CITY OF ALBUQUERQUE

October 9, 2012

**Re: Tuan Van Huynh Residence Grading and Drainage Plan
Engineer's Stamp dated 08-25-12 (L-23/D001D)**

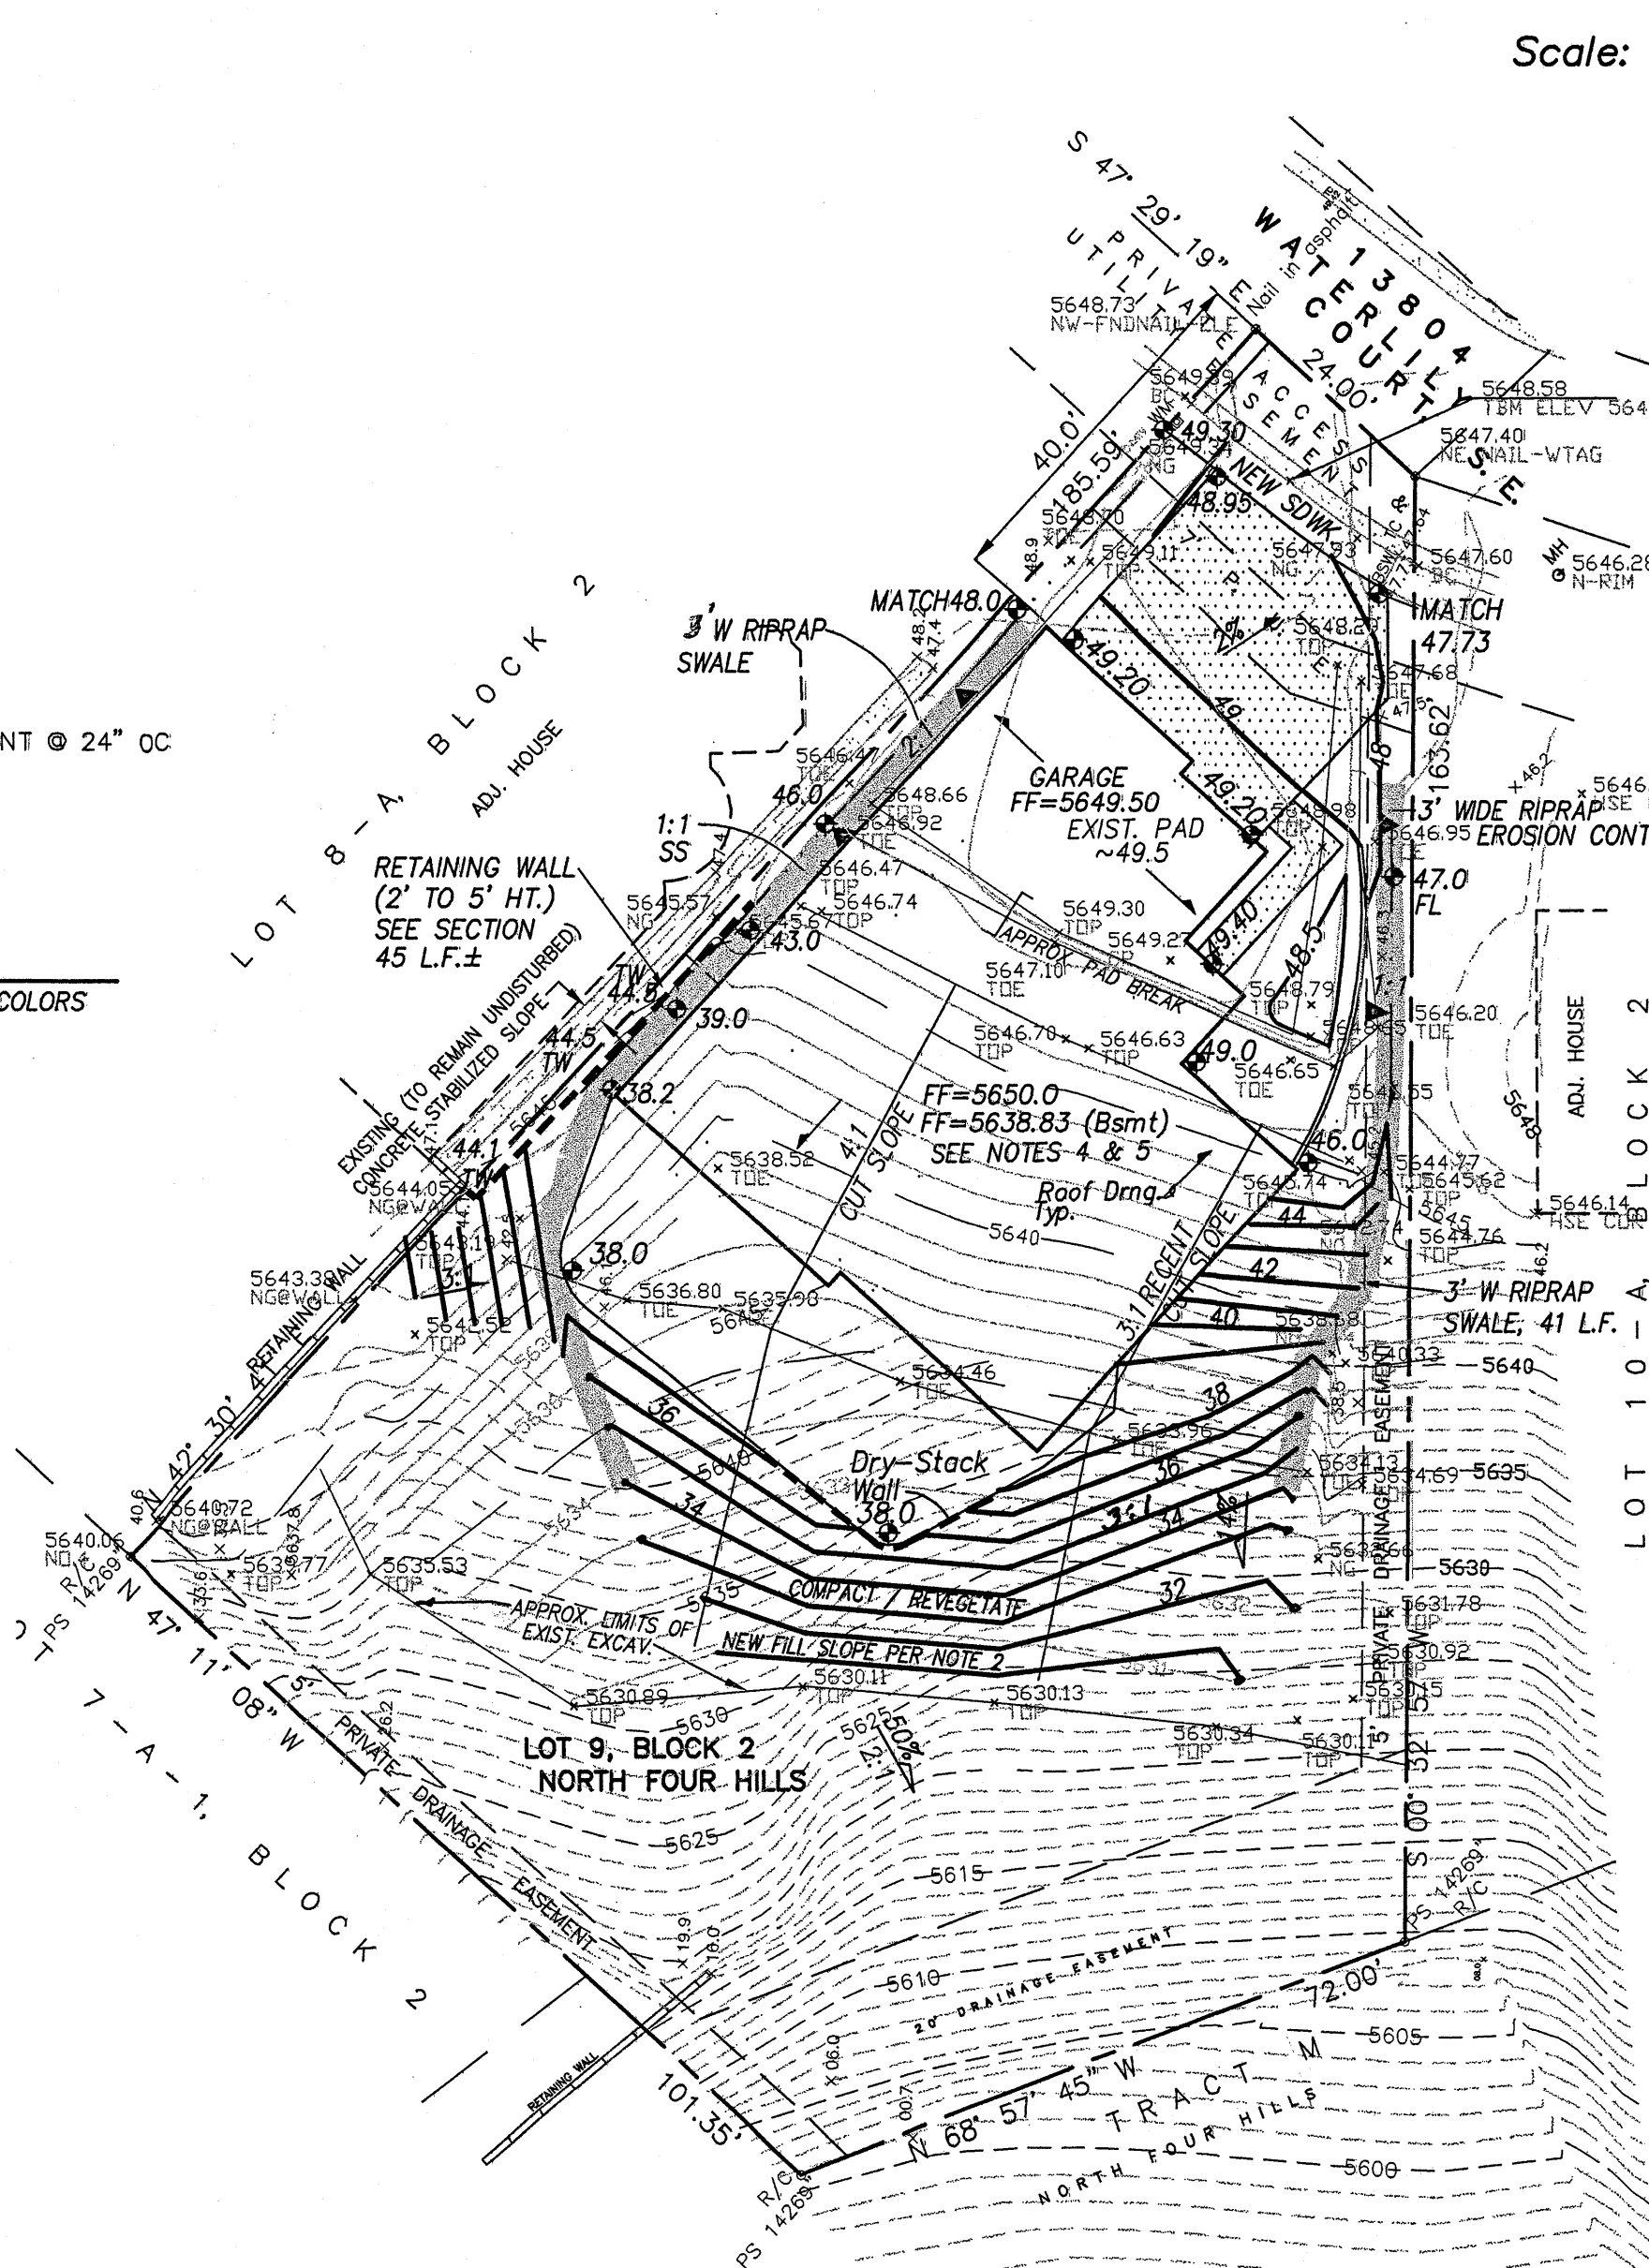
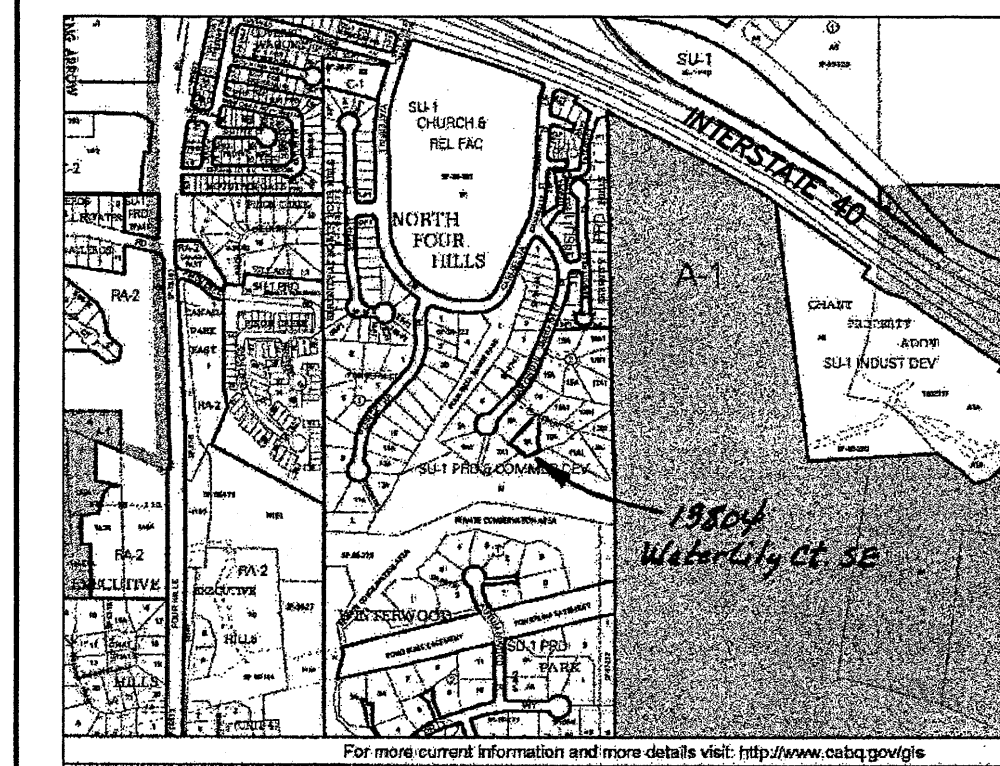
- Since the topography does not represent the exiting graded areas, as-built grades will be required.
- Slopes treatment will be needed for the slopes exceeding 3:1 grades.
- There is also an existing retaining wall within the 5' drainage easement along the southerly boundary. Need to make sure that this retaining wall will adversely impact the offsite runoff.
- No runoff should drain over the slopes to the south. The runoff from the constructed area should be intercepted by inlet(s) and piped to the bottom of the slopes.
- A variance will be required if the proposed wall shown on the plan exceeds 8' (retaining wall + garden wall).
